WEST SUSSEX COUNTY COUNCIL CONSULTATION

TO:	Arun District Council FAO: Anita Gardner
FROM:	WSCC - Highways Authority
DATE:	5 November 2020
LOCATION:	57 River Road Littlehampton BN17 5DD
SUBJECT:	LU/247/20/PL Partial demolition of existing building, retention of boundary wall & street facade, partial demolition of boundary wall to incorporate new pedestrian gateway & gate, erection of 6 No. flats in 2 blocks connected by shared stair & lift core, on site parking yard for 8 No. cars & 8 No. cycles & space for communal refuse & recycling bins. This application affects the character & appearance of the Littlehampton River Road Conservation Area & is in CIL Zone 4 (Zero Rated) as flats.
DATE OF SITE VISIT:	n/a
RECOMMENDATION:	More Information
S106 CONTRIBUTION TOTAL:	n/a

DRAWING NO: 1908_P_200 REVISION 01

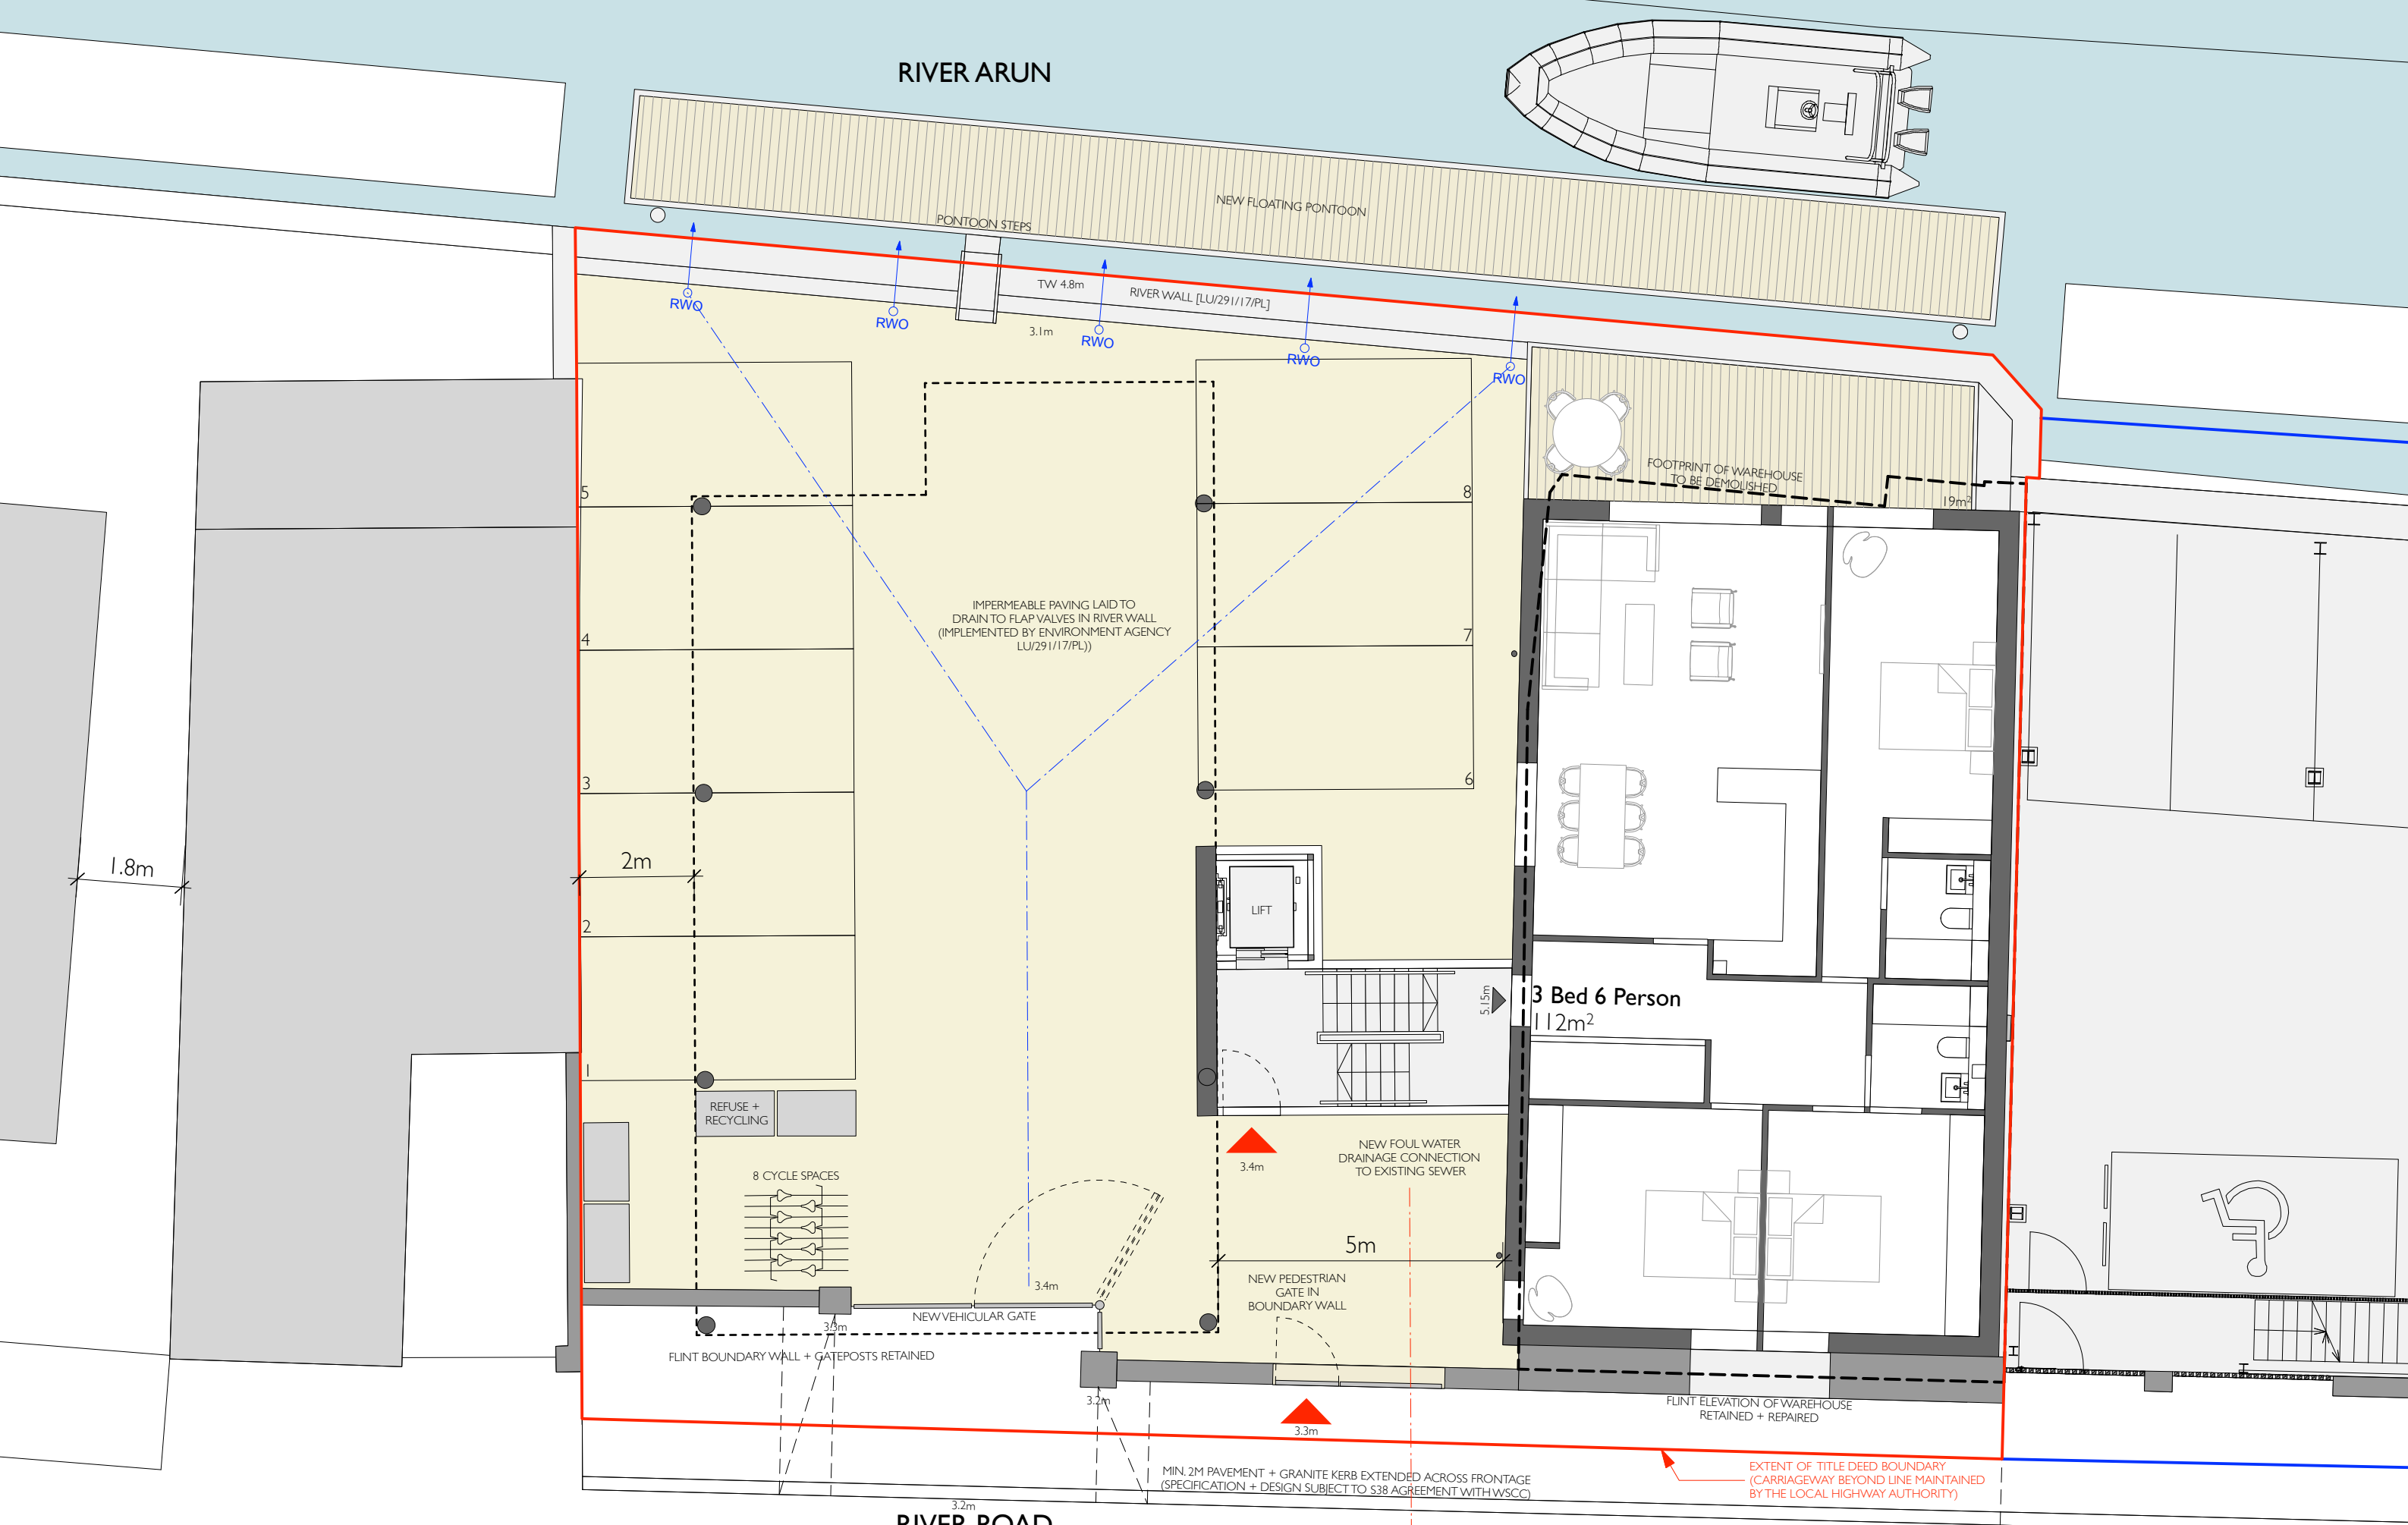
The LHA has been re-consulted on this application following submission of revised plans demonstrating that the applicant owns the land to the front of the site, and that there is no third party land issue in this location.

The applicant is requested to provide trip generation details pertaining to the existing use of the site as a vehicle repair shop, to enable the LHA to establish whether the proposal would represent a material intensification of use.
